# City of Albuquerque Stormwater Construction Site Inspection Report

ESC File No.	D10E002D	Project Name:	La Cuentiasta III & Stockpile		
NPDES Id. No.	NMR1004P9	Location:	Rosa Parks and Kimmick		
7/14/2022	Owner	Contractor			
Operator	Pulte Homes of NM	Guzman Construction			
Contact name & title	Kevin Patten	Rudy Guzman			
e-mail	<a href="mailto:Kevin.Patton@PulteGroup.com">Kevin.Patton@PulteGroup.com</a>	<a href="mailto:rudy@guzmancs.com">rudy@guzmancs.com</a>			
Contact Phone #	505-341-8591	505-459-3128			
COA Inspector	Doug Hughes	Start/End Time:	10am		
Construction Phase:	Staging				
Type of Inspection:	Regular	Storm Event	Past Storm Event >0.25"	311/Complaint	Follow Up
Weather at time of inspection?		Clear		Temperature: ~ 90	
Estimated date of last storm 0.25" or greater		7/12/2022

TEMPORARY EROSION AND SEDIMENT CONTROL PLAN

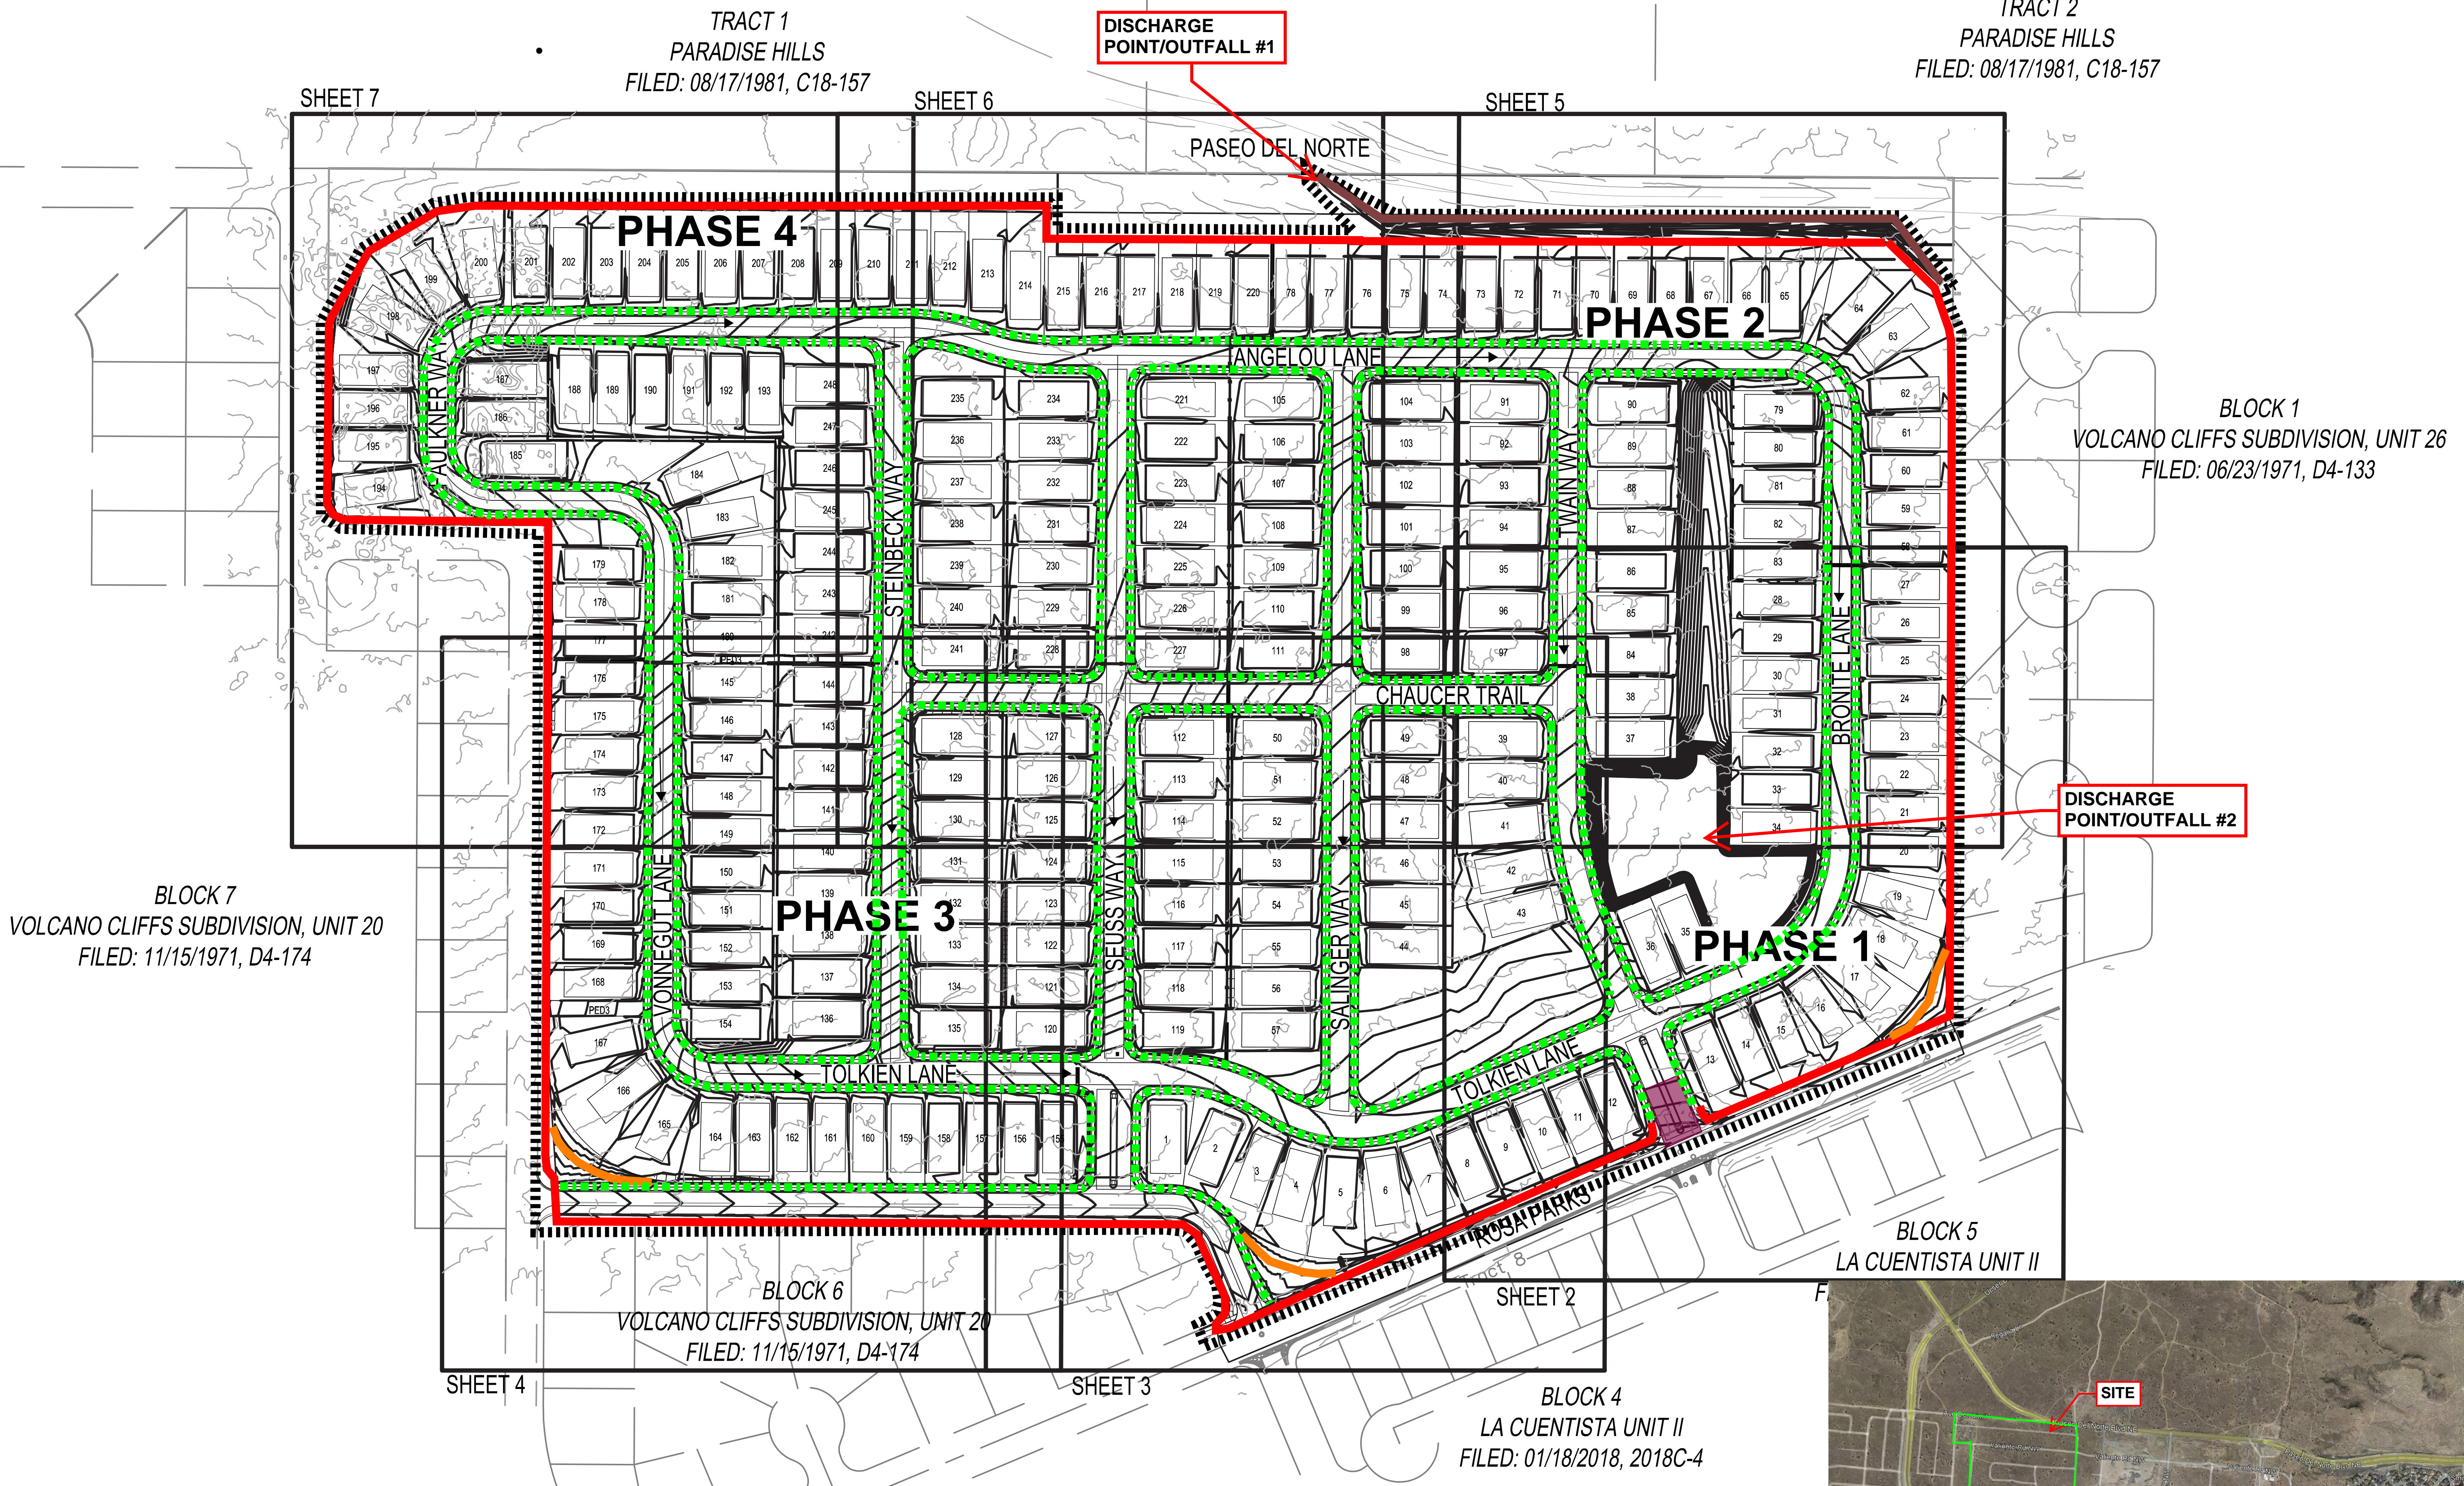
Item Number	Deficiency/ Corrective Action				
1	BMPs were missing at the staging/stockpile area.				
2	The property owner's NOIs are missing for the stockpile/staging area, so it doesn't have NPDES Permit coverage. Most of the stockpile is located on the 2.5-acre Tract 5 Block 6 owned by 'Tract 5 U26, LLC' whose address is the same as Guzman Construction. Tracts 1, 2, and 3 (1.2ac total) are entirely covered by recent land disturbing activities, but the 40' stockpile is mostly east of these lots. The stockpile doesn't encroach into the larger 15 ac tract to the east, but the water tank, porta potty, and three haul roads are located on a portion of Tract 1 Blk 2 Plat of Tr1 Blk 2 Volcano Cliffs Subdivision Unit 26 (15ac). Much of the newly disturbed area drains to an inlet on the 15-ac tract.				
3	The SWPPP isn't up-to-date because all information on the staging area (NOIs & BMPs) are missing. The SWPPP map needs updating.

Notes:	
The SWPPP is in the lockbox on the posting sign and is up-to-date, except the stockpile/staging area is missing. Both Pulte and Guzman emailed saying their intent is to add to stockpile to this SWPPP and add the missing Property owner's NOIs.
